<b>Application Ref:</b>	3/2021/0177	 Ribble Valley Borough Council <a href="http://www.ribblevalley.gov.uk">www.ribblevalley.gov.uk</a>
<b>Date Inspected:</b>	N/A	
<b>Officer:</b>	BT	
<b>DELEGATED ITEM FILE REPORT:</b>	<b>NON MATERIAL AMENDMENT</b>

<b>Application Description:</b>	Non Material Amendment of Planning Application 3/2020/1055. Proposed change in colour of fascia boards from white to black; change of white UPVC windows and doors to black aluminium; change utility door from white UPVC to colour composite; delete small window in utility room; insert high level window in the family room on the side elevation; change orientation of roof lantern in kitchen/dining room and increase size to 2.4m x 1.2m.
<b>Site Address/Location:</b>	Mayfield, Whalley Road, Simonstone. BB12 7HT

PROPOSED FLOOR PLANS, ELEVATIONS, SECTION & ROOF PLAN

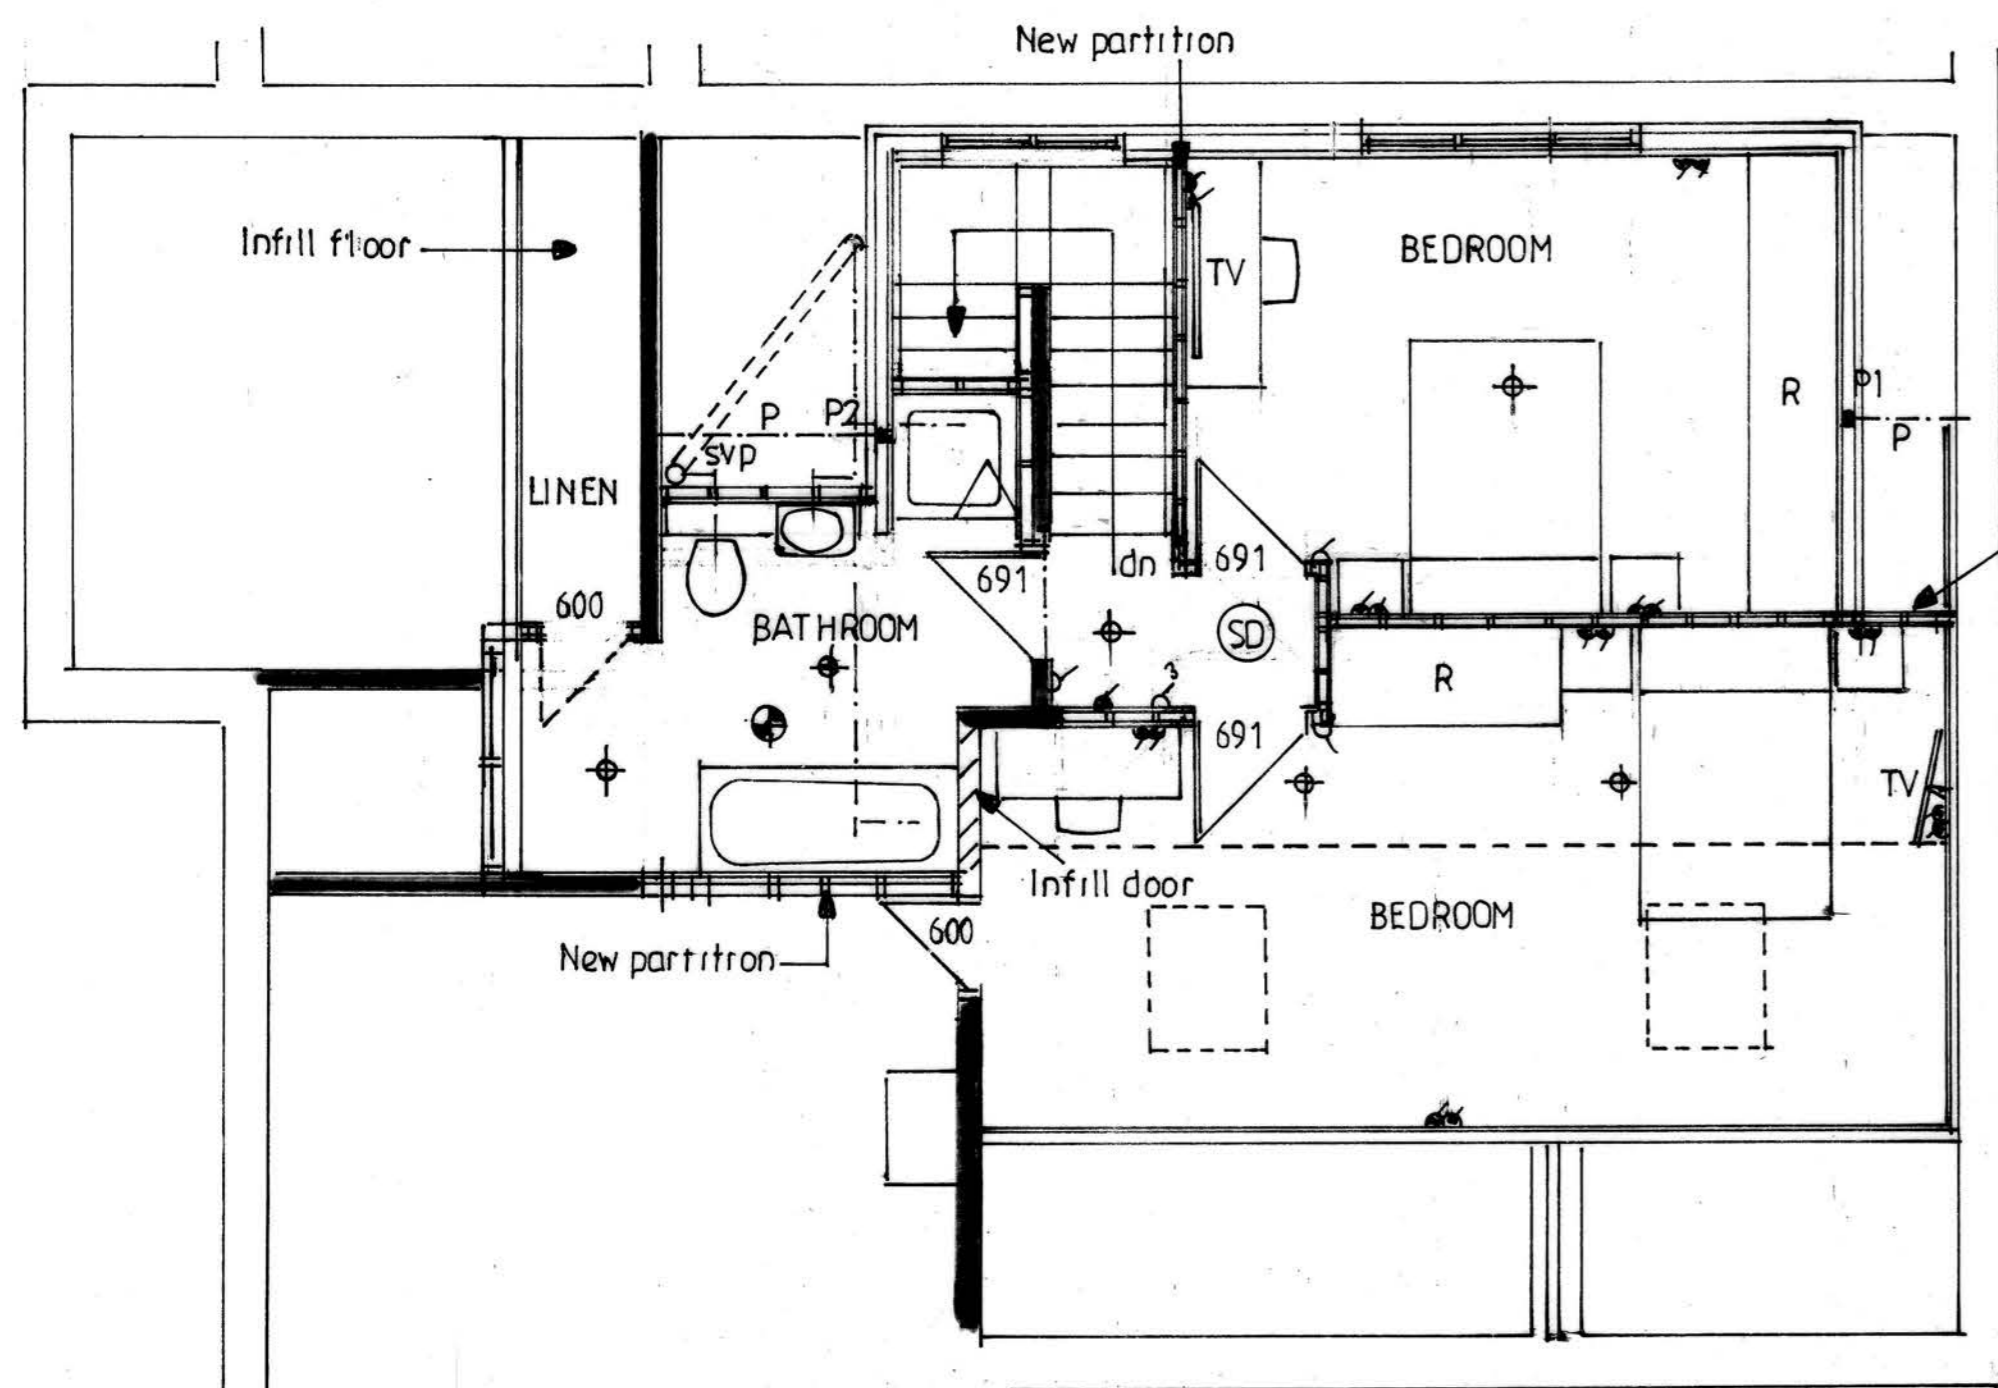
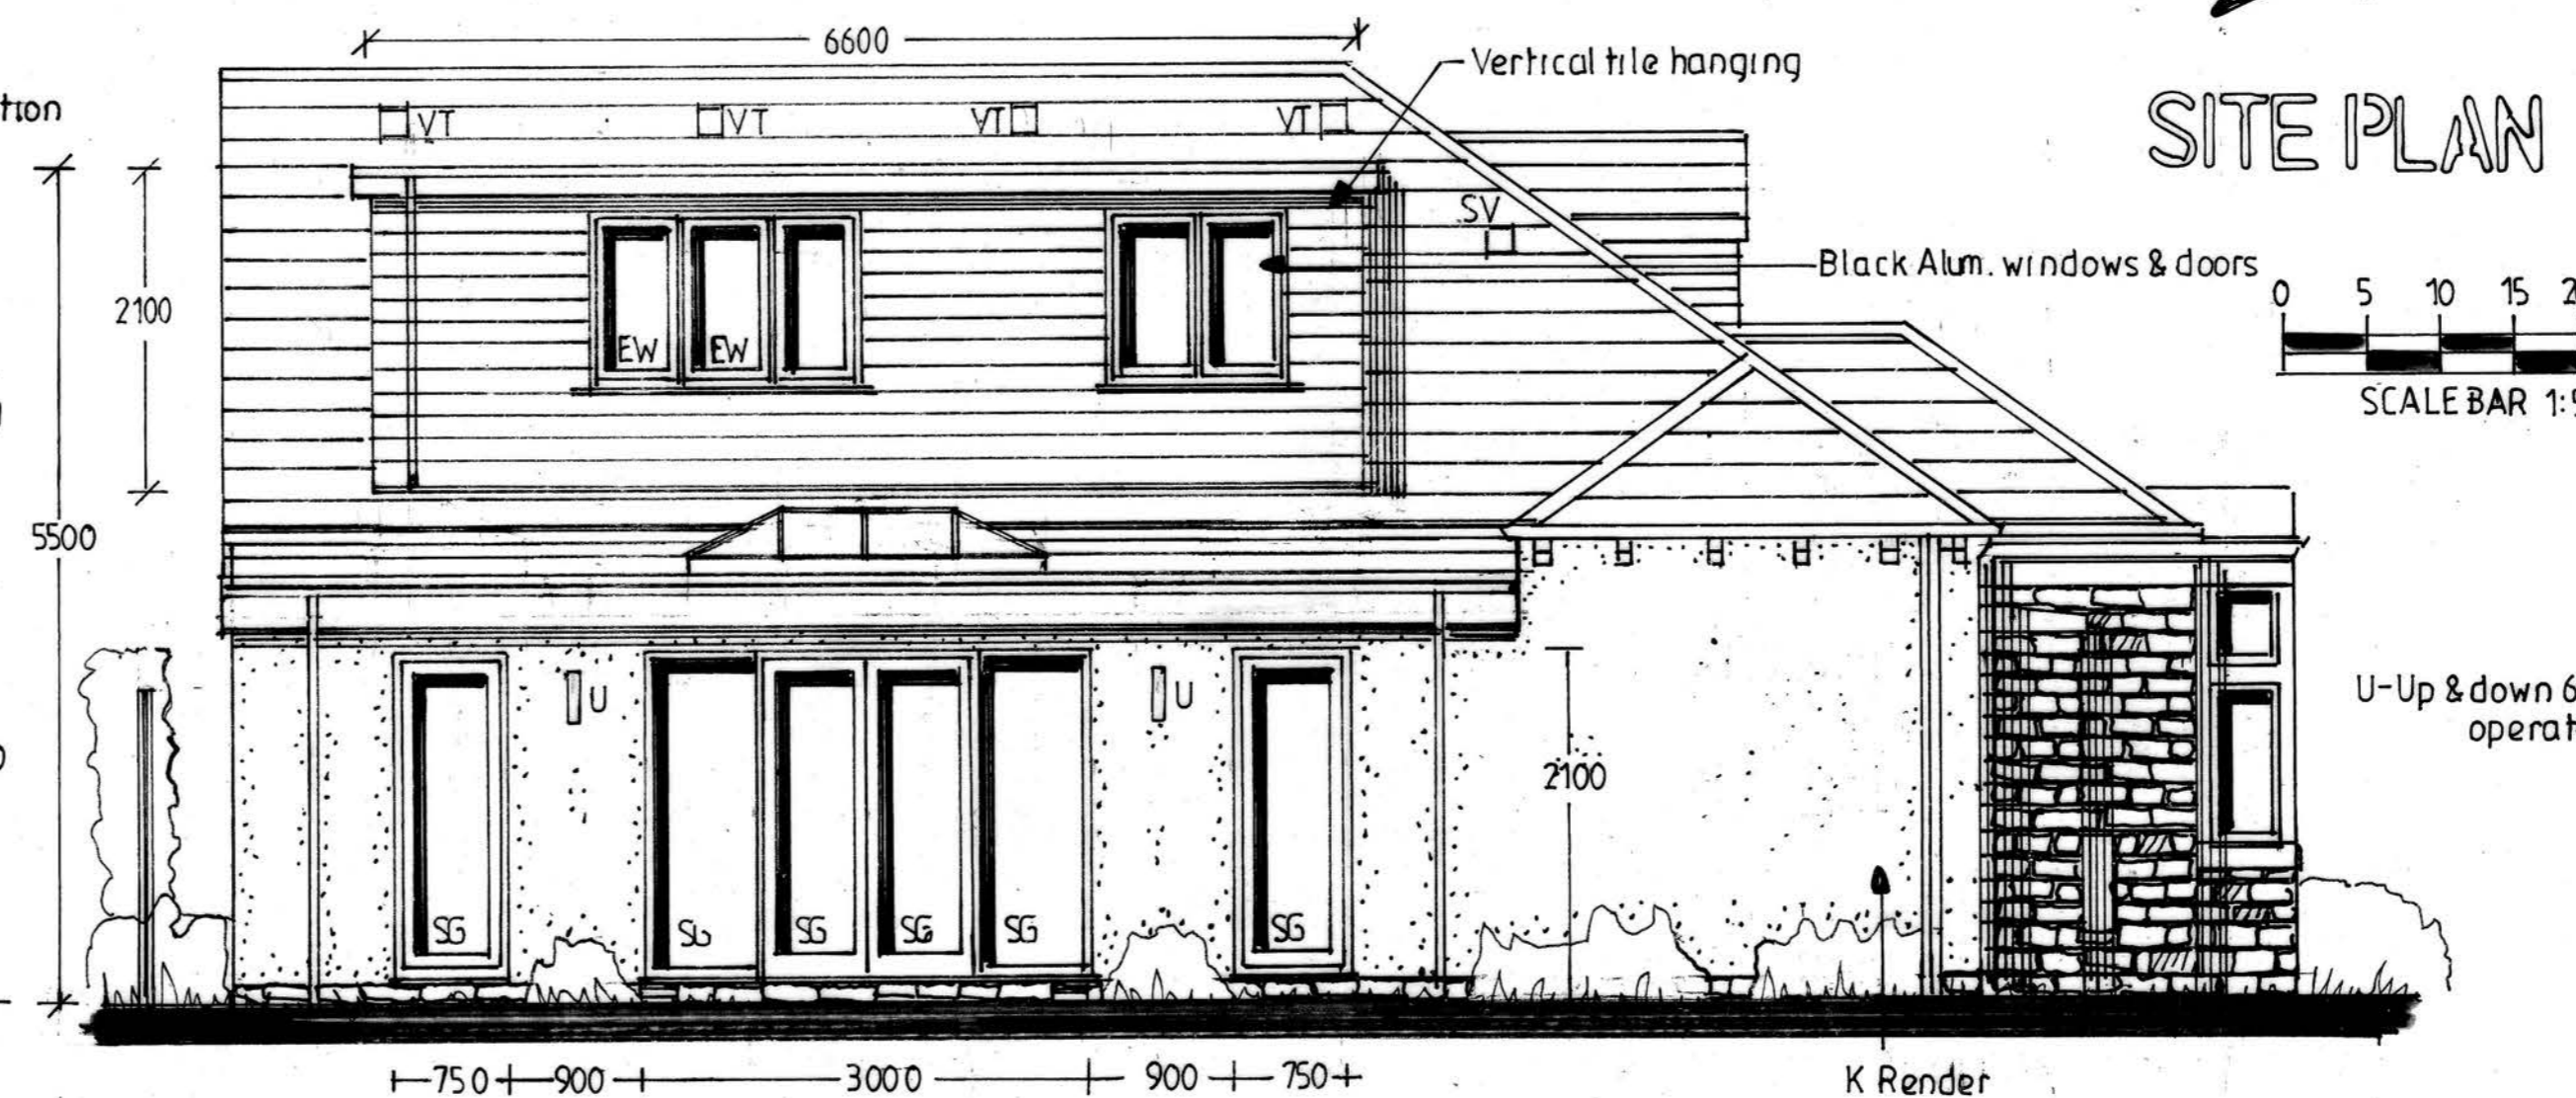
- Removal of small window in utility room
- Insertion of high level window in the family room on the side elevation
- Change orientation of roof lantern in kitchen / dining room and increase size to 2.4m x 1.2m

The applicant has stated that the existing white UPVC windows and doors that were to be retained as part of the approved proposal were found to be in poor condition and in need of replacement hence the applicant wishes to change these to a black aluminium style. The applicant also wishes to change the colour of the proposed fascia boards from white to black in order to integrate with the new UPVC windows and doors.

The applicant has stated that the small window in the utility room is being deleted to allow for additional high level storage units. The applicant also wishes to make minor changes to the orientation and size of the proposed roof lantern in order to provide more light into the property's kitchen.

The application also includes plans to insert a high level window on the South-eastern elevation of the property's in order to provide supplementary light and ventilation into the property's family room. The proposed window would be sited 2 metres above ground level and would cover a maximum surface area of 1 square metre.

The window would be situated above head height and would face towards the gable end of the neighbouring property which does not contain any windows which form part of habitable rooms. As such, it is not considered that the high level window would have any significant impact upon the residential amenity of the neighbouring residents with regards to loss of privacy through overlooking. Moreover, the proposed window would fall within the realm of permitted development by virtue of its positioning on the original house.

The non-material amendment should be granted.

Approve non-material amendment.
